DECISION DELEGATED TO HEAD OF PLANNING

Application No: H09-1079-24 **Applicant:** A Sukerno
Proposal: Proposed residential development - 9 dwellings
Location: Hooks Of Holbeach Land Adj & Including 45 Fleet Street Holbeach
Terminal Date: 28th February 2025

Drawing
SITE PLAN - EXISTING & PROPOSED
LOCATION PLAN

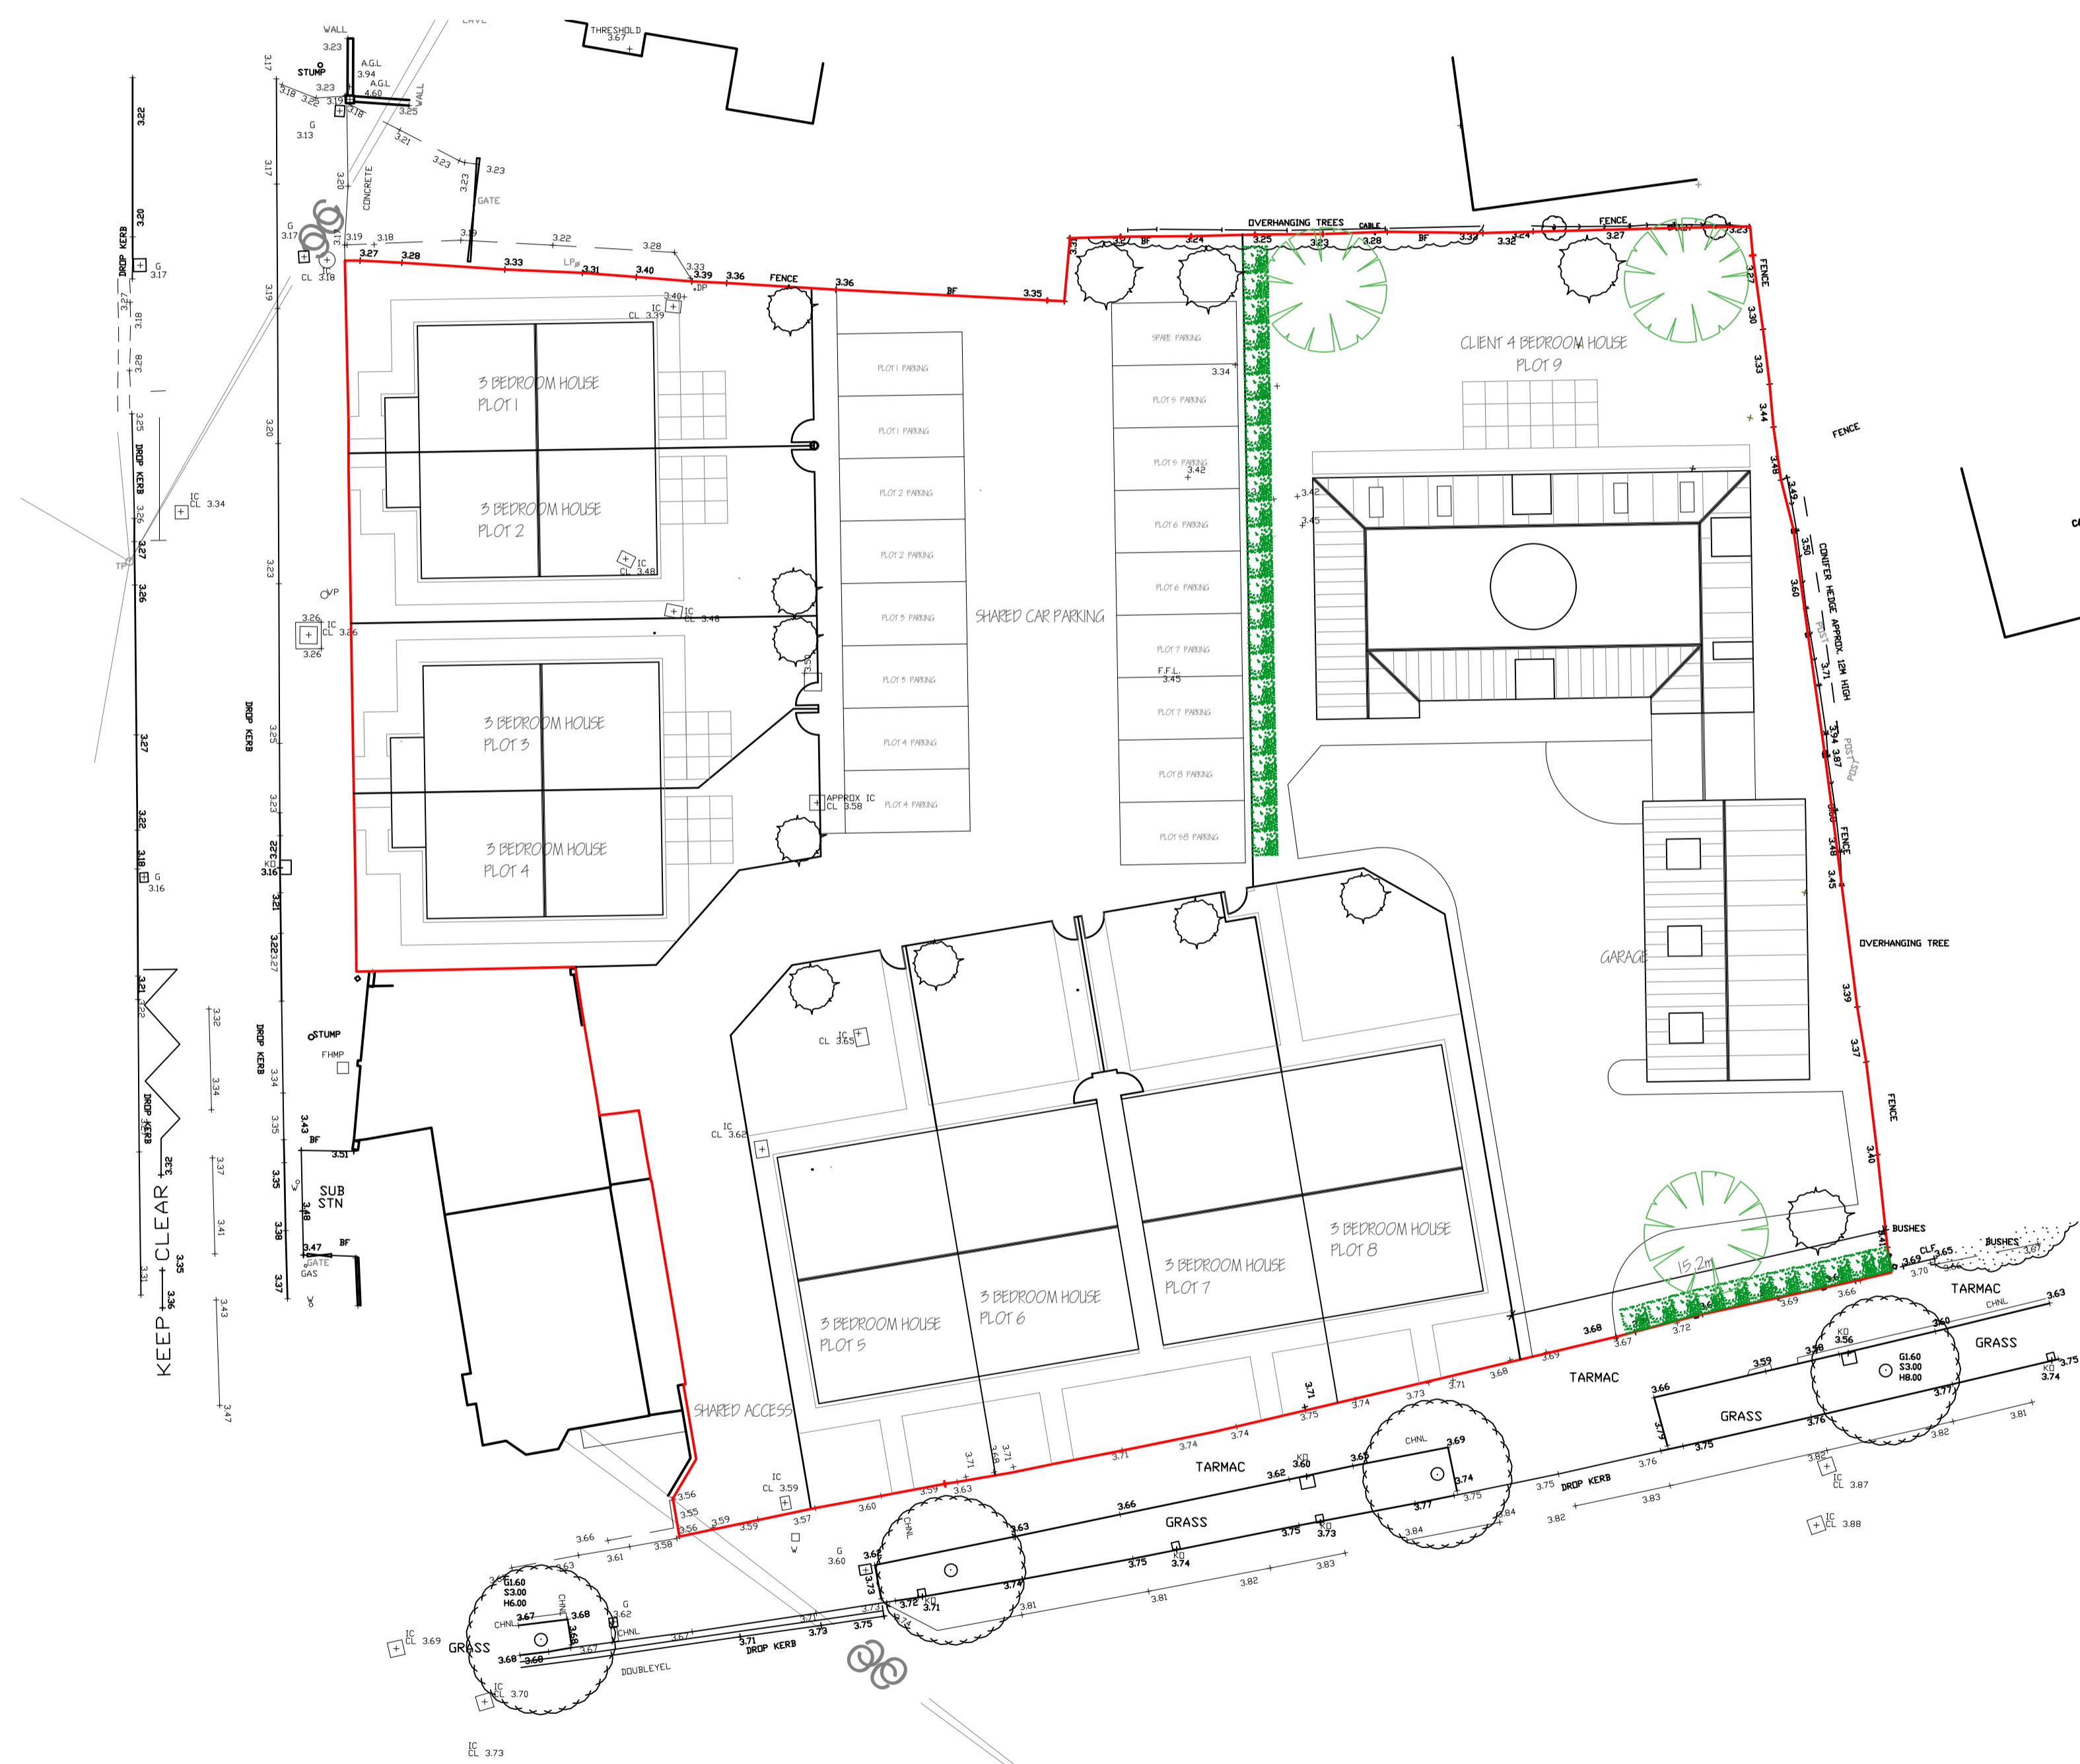
The access widths are to be detailed on the proposed site plan. The access proposed to be shared should measure 4.1m for the first 10m thereafter it should be a minimum of 3.7m.

The Red line in is the highway. The public highway goes up to the existing build line on Edinburgh Walk this needs amending. A street scene drawing is required of plots 1-4.
